RE: **Coors Blvd Wecks**
730 Coors Blvd NW
Grading and Drainage Plan
Engineer's Stamp Date: 12/11/2018
Hydrology File: J11D032

Based on the submittal received on 12/21/18, the Grading and Drainage Plan cannot be approved for Site Plan for Building Permit (Administrative Amendment) or Building Permit until the following corrections are made:

Grading Plan

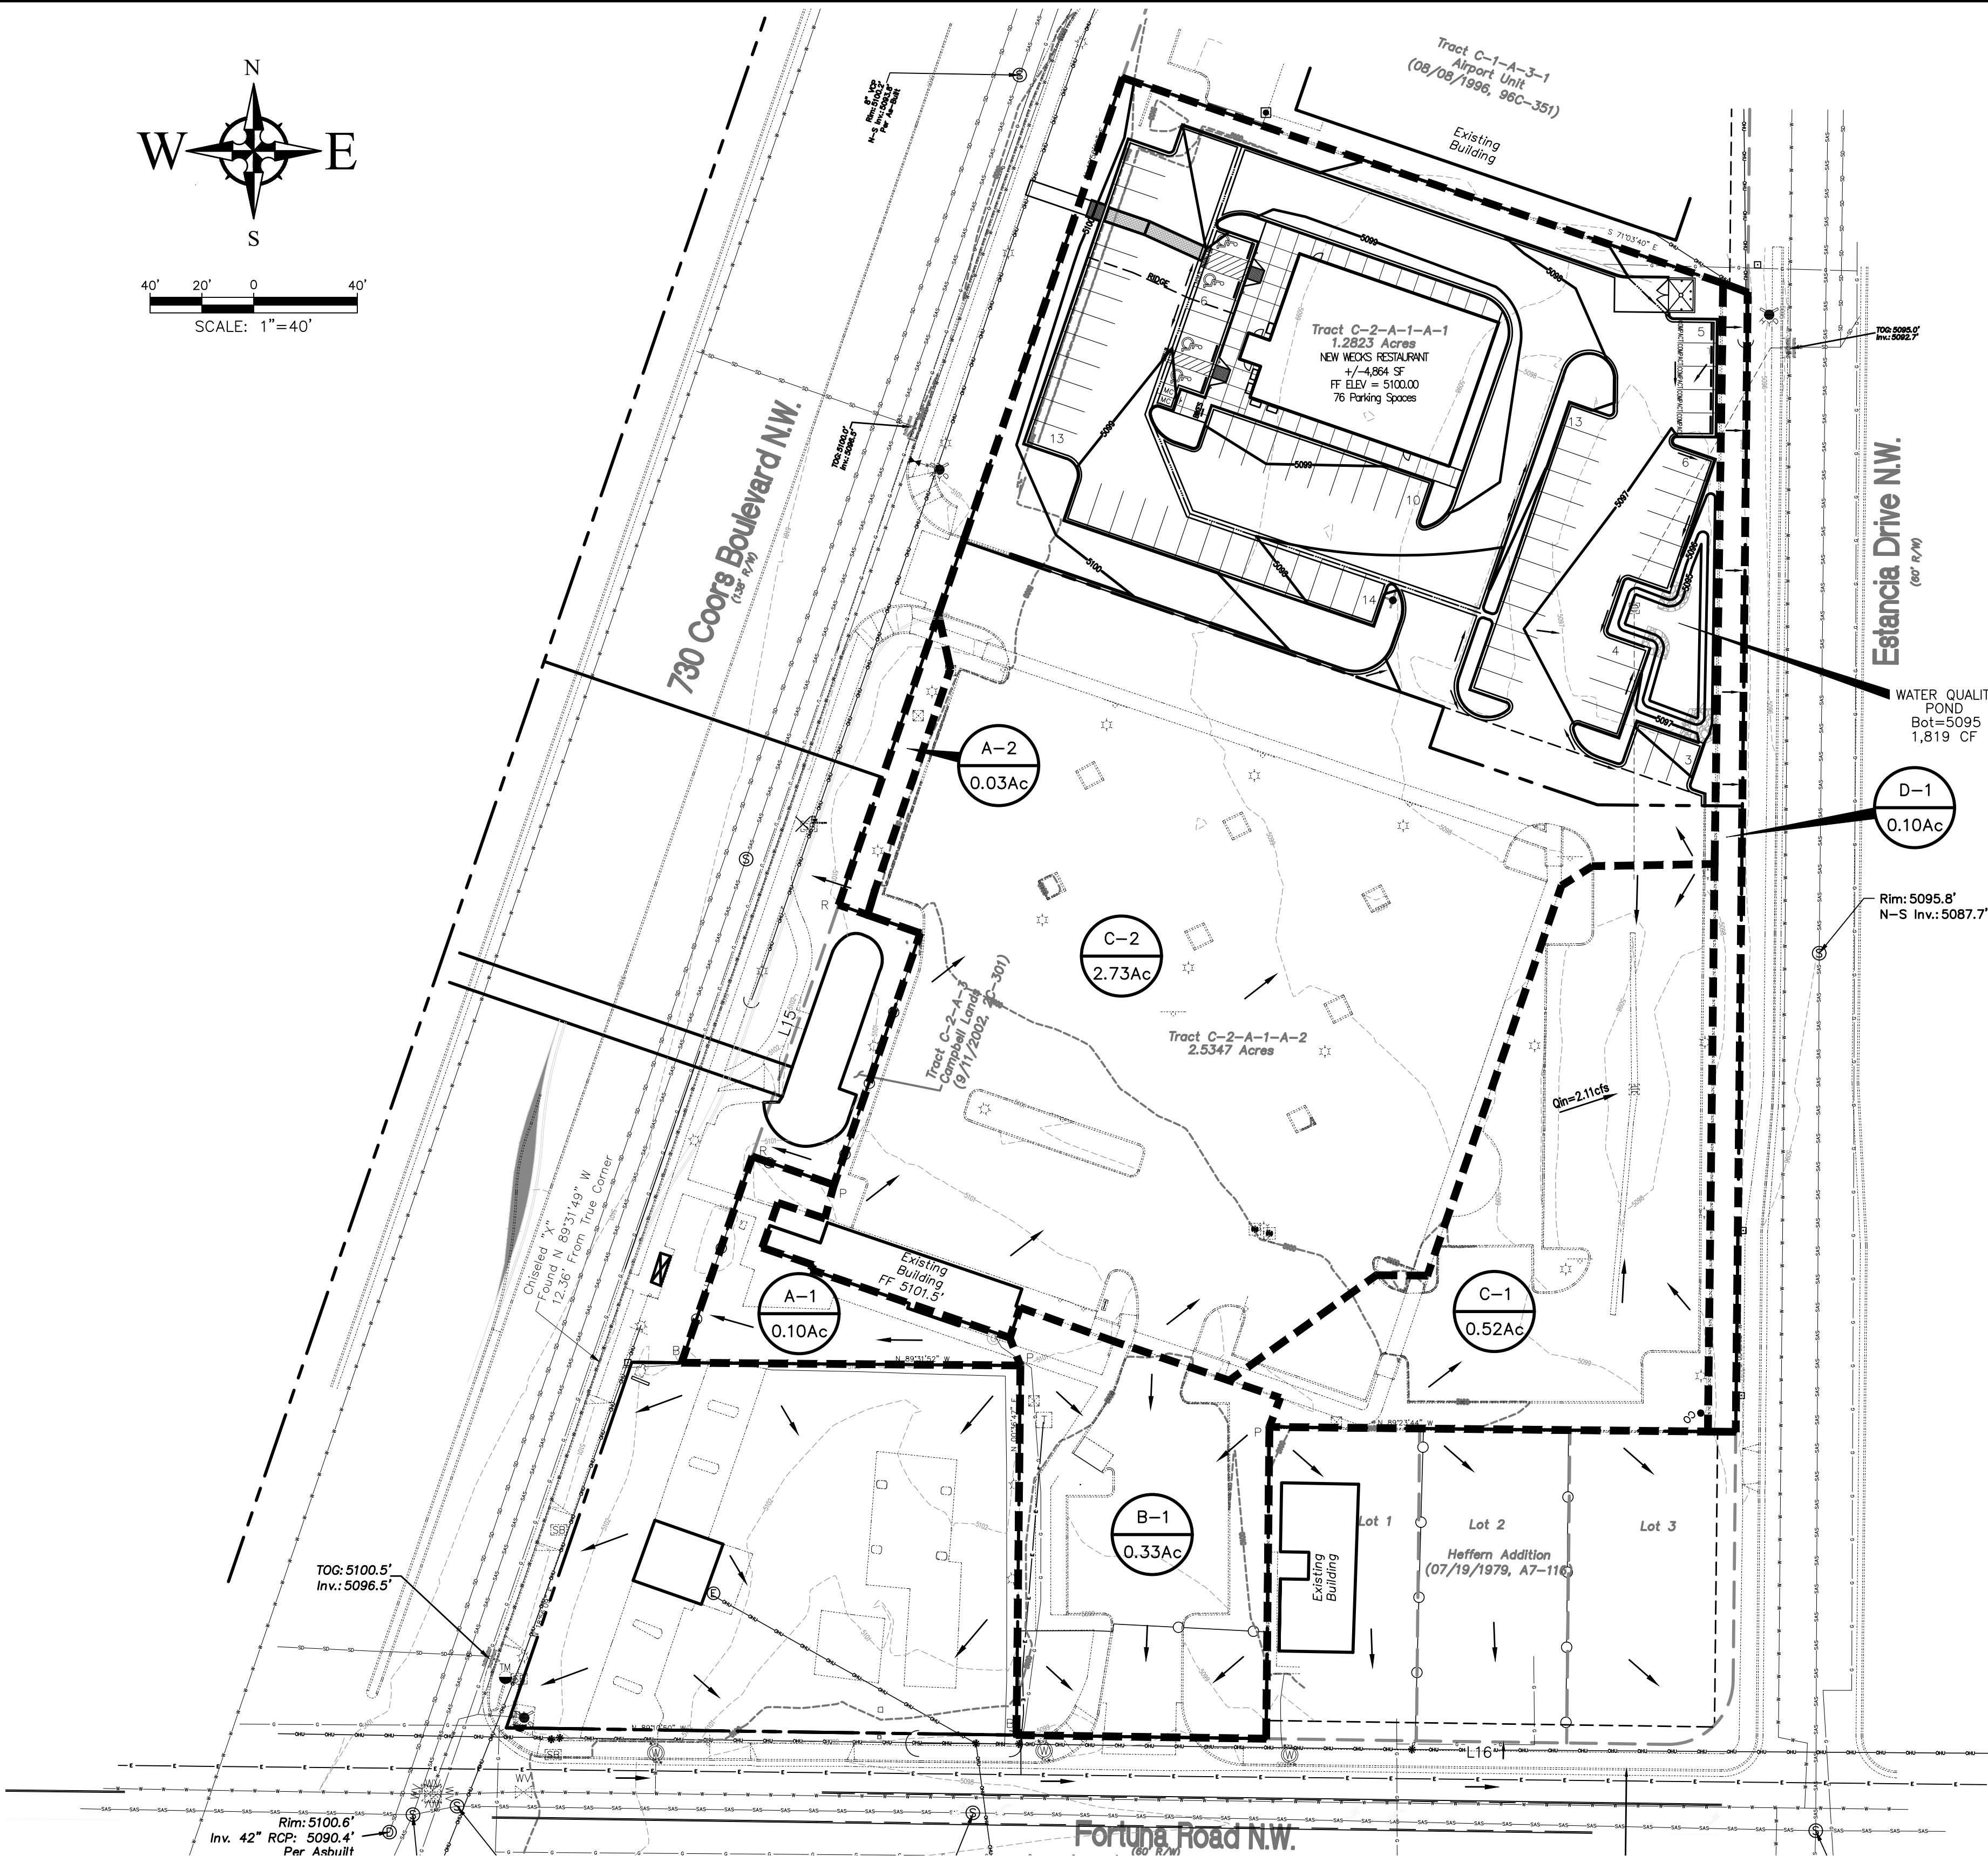
1. If only seeking Site Plan for Building Permit approval at this time, label the grading plan "Conceptual, Not For Construction" or similar. If seeking SPBP and Building Permit simultaneously, forgo the conceptual markings and address all Building Permit comments.

2. For trash enclosures serving food service developments, demonstrate control of liquids from dumpster areas per DPM Chapter 22.9.E, Table 1 by containing runoff from the dumpster area and discharging to the sanitary sewer. If this information is on the utility plan please provide it, or show on the grading plan.
3. This project requires an ESC Plan, submitted to the Stormwater Quality Engineer (Curtis Cherne PE, ccherne@cabq.gov or 924-3420).
4. Add note on the plan that "No work shall be performed in the public ROW without an approved Work Order or Excavation Permit."
5. For Information. Hydrology and Transportation files are available online through the City's GIS Viewer 2.0: <https://www.cabq.gov/gis/advanced-map-viewer>. Turn on the *HydroTrans*
